### **Condition 5: Surface Water Drainage**

The text below in red provides a written response to Condition 3: Surface Water Drainage. The responses also refer to drawings which have been submitted as evidence alongside the condition discharge application.

Drawing Title:
Site Location Plan

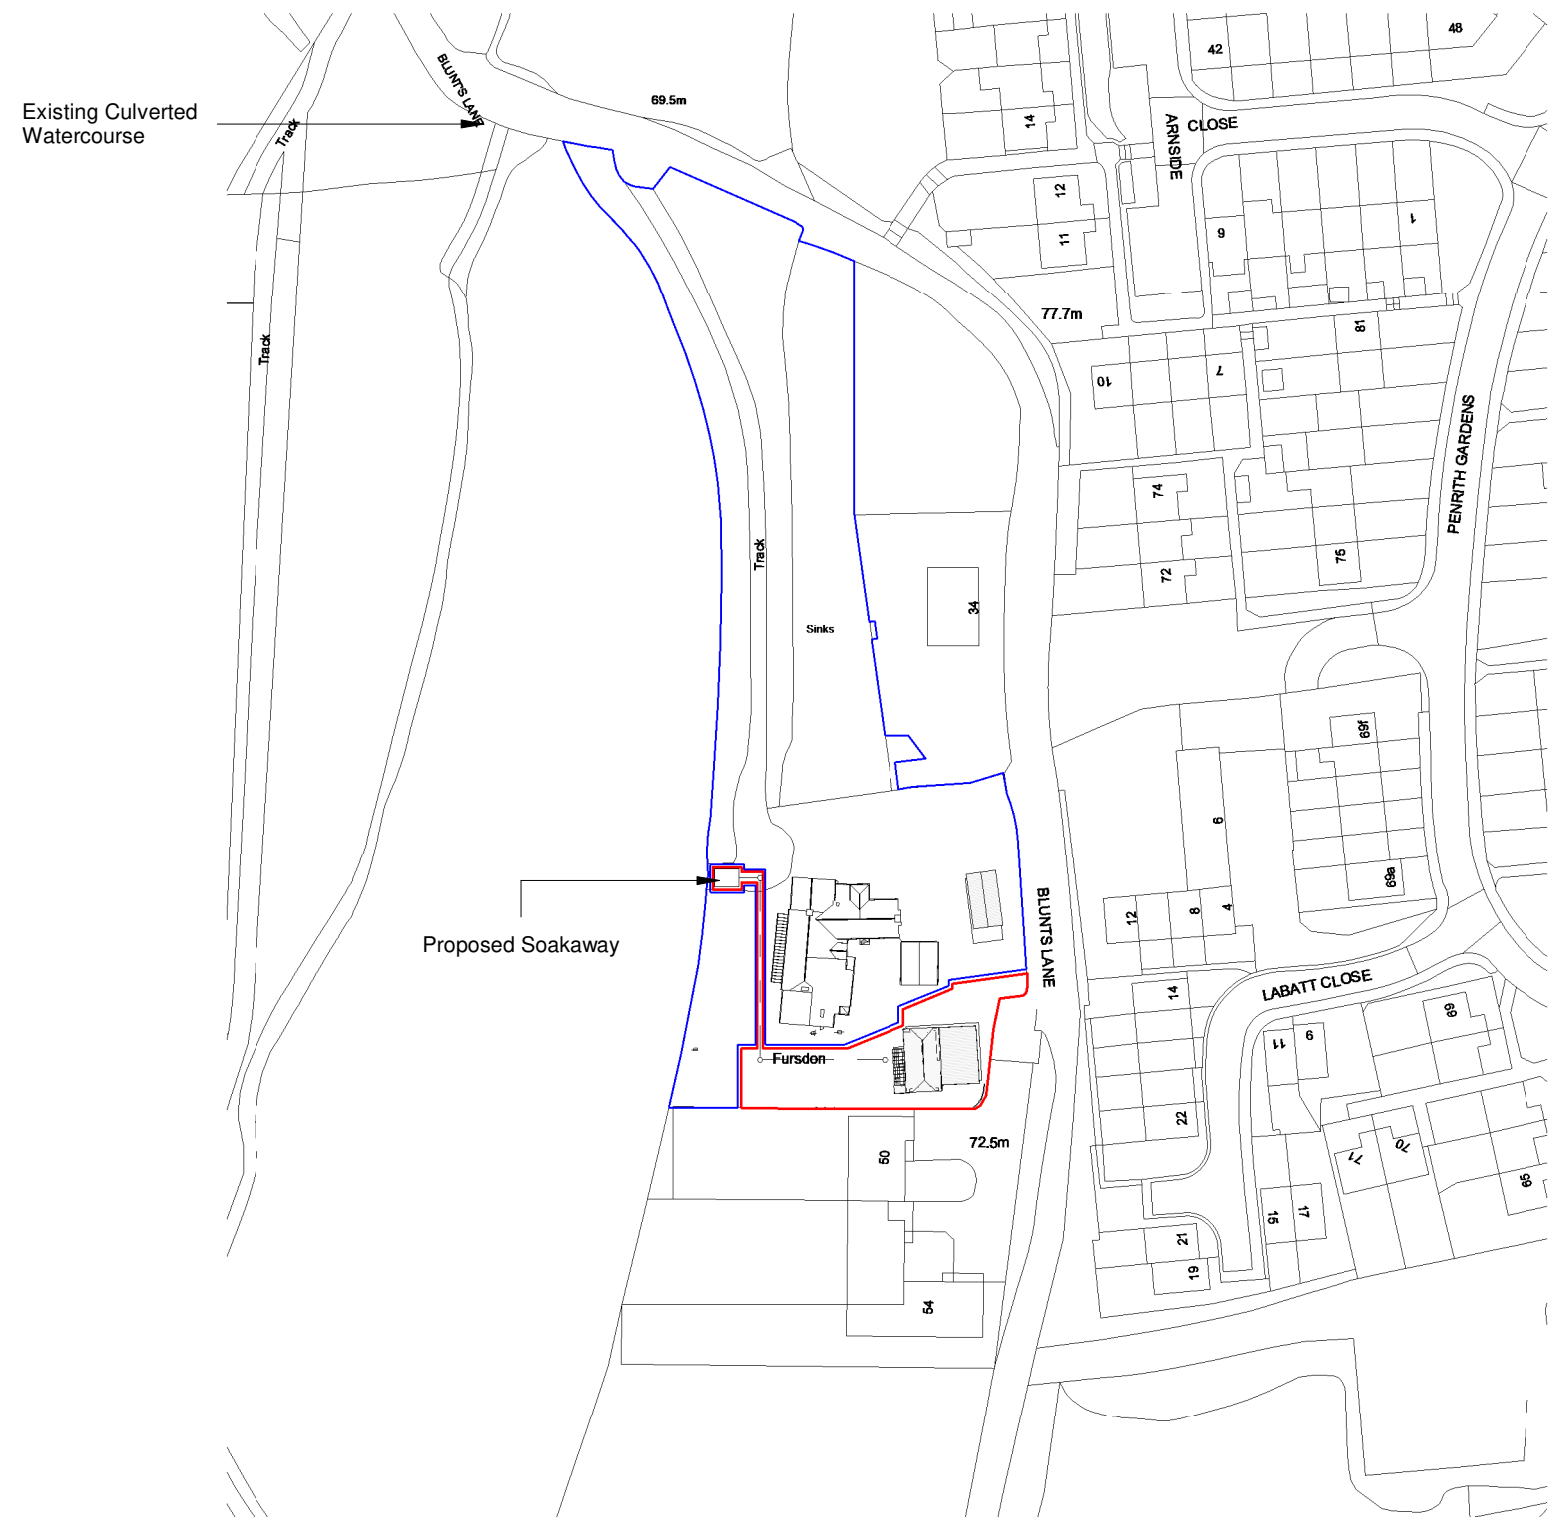
- B) *'Confirmation should be submitted that the proposed soakaway is located a minimum of 5m from the existing culverted watercourse identified as having the potential to be in close proximity to the proposed soakaway'* – The stream at the bottom of the hill is 50 meters away, whilst the man-made culvert is over 100 meters away from the Proposed Soakaway. See drawing '23283-ADG-XX-XX-EX-A-9001-E Site Location Plan'.

Drawing Title:
Proposed Block Plan

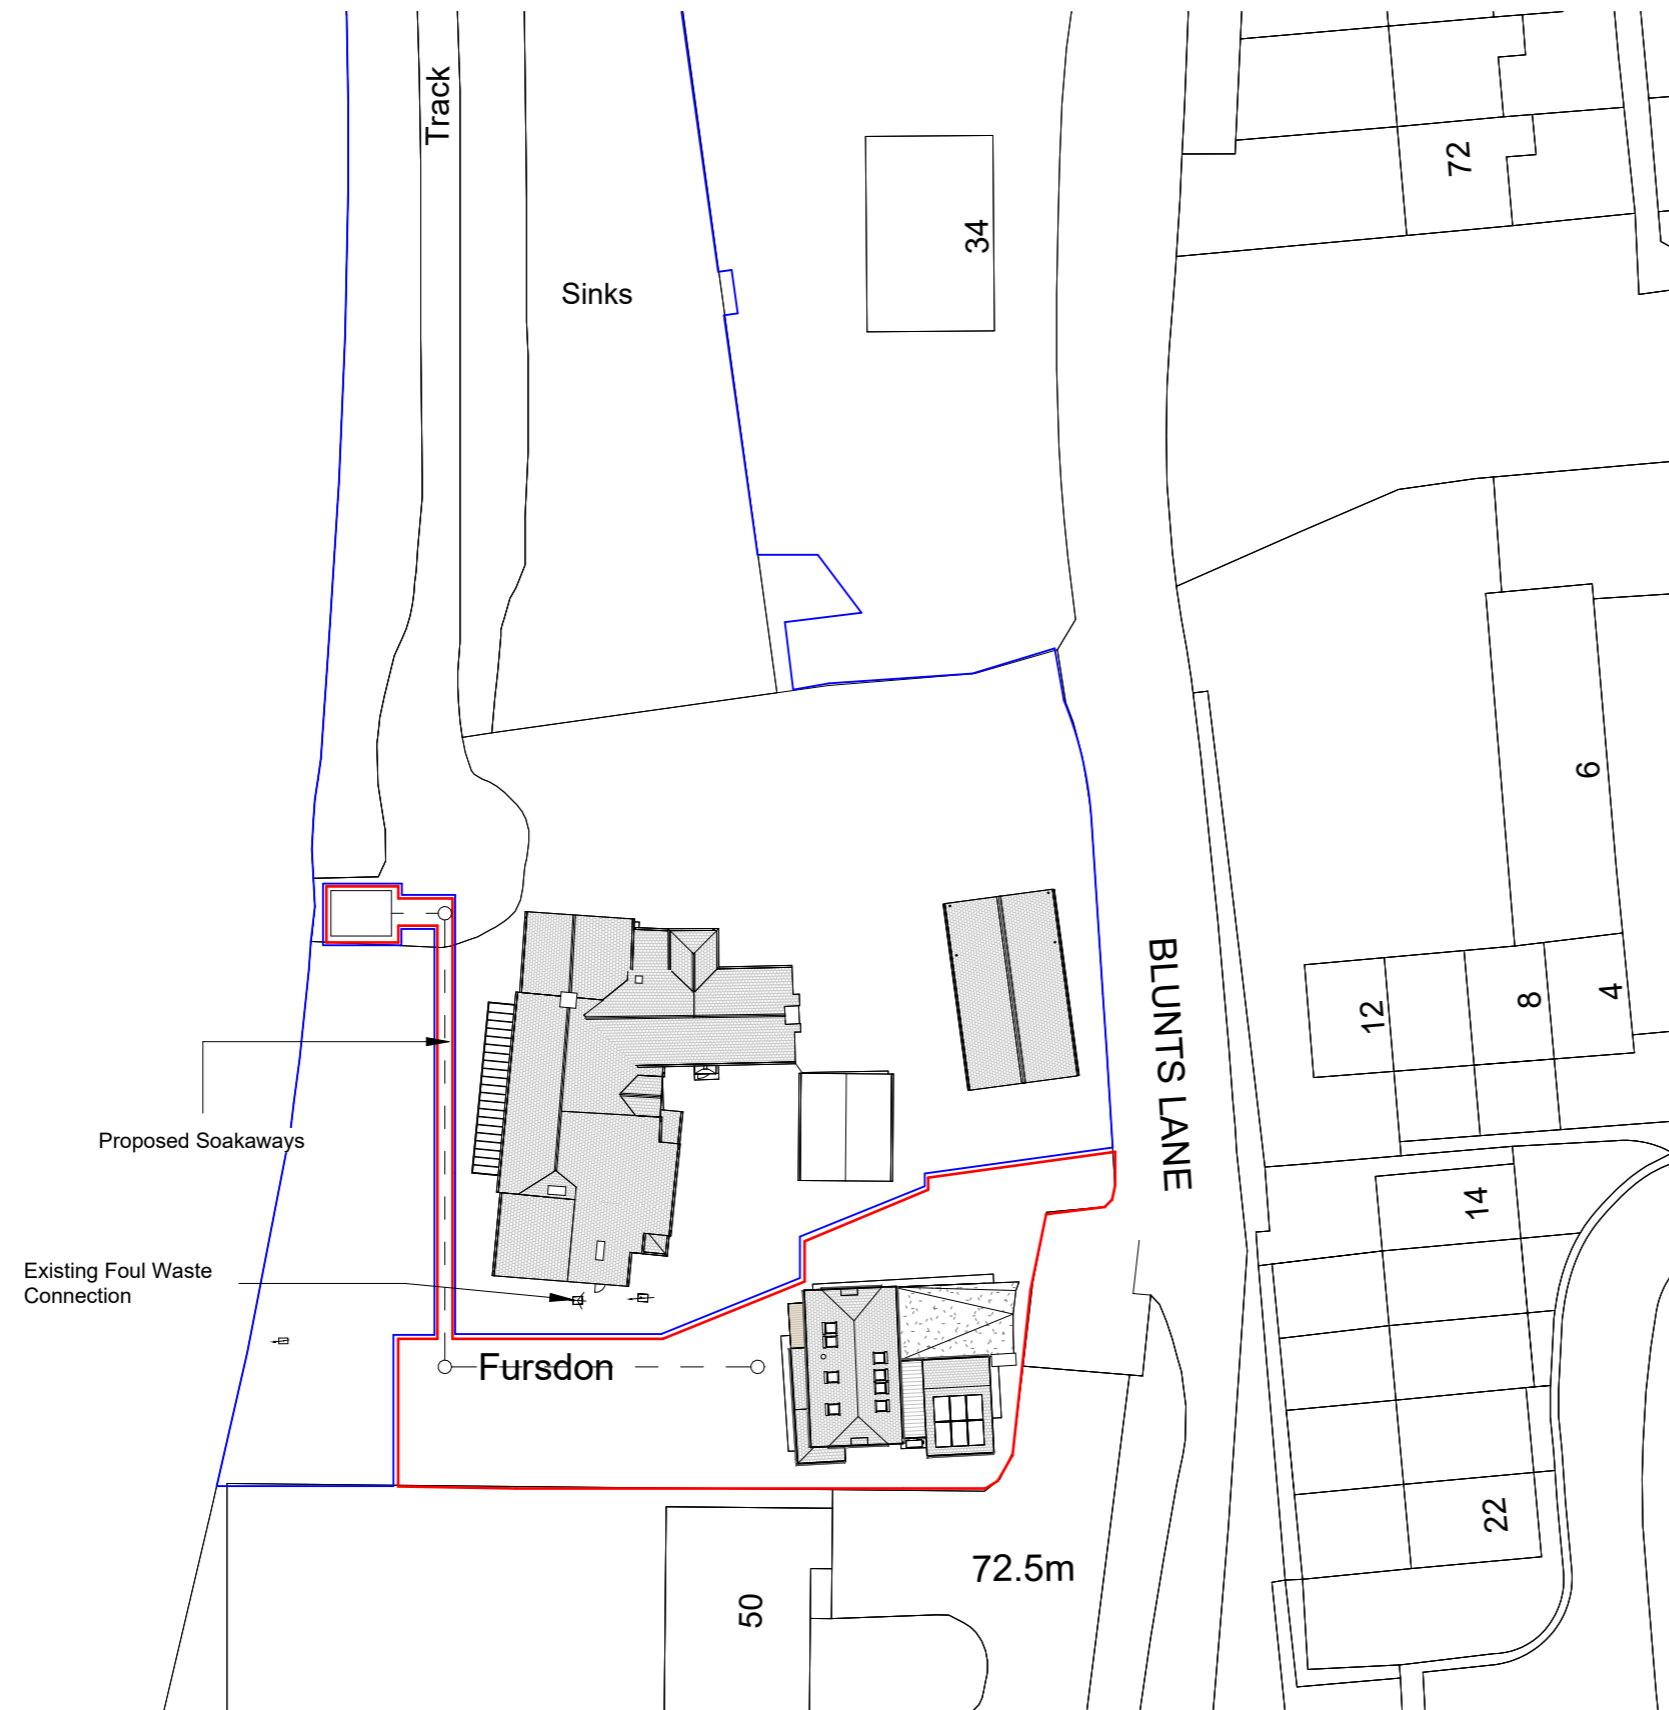
- A) *'Written approval from the land owner is also required guaranteeing access for maintenance for the lifetime of the proposed development.'* – The owners' boundary line is located and clearly displayed on all site plan drawings, indicating the soakaways are within the owner's land. See boundary line in drawings '23283-ADG-XX-XX-EX-A-9001-E Site Location Plan', '23283-ADG-XX-XX-EX-D-9002-D Existing Site Block Plan', '23283-ADG-XX-XX-EX-D-9003-C Existing Survey Plan', '23283-ADG-XX-XX-EX-D-9011-E Proposed Site Layout Plan', '23283-ADG-XX-XX-EX-A-9002-E Proposed Block Plan'.
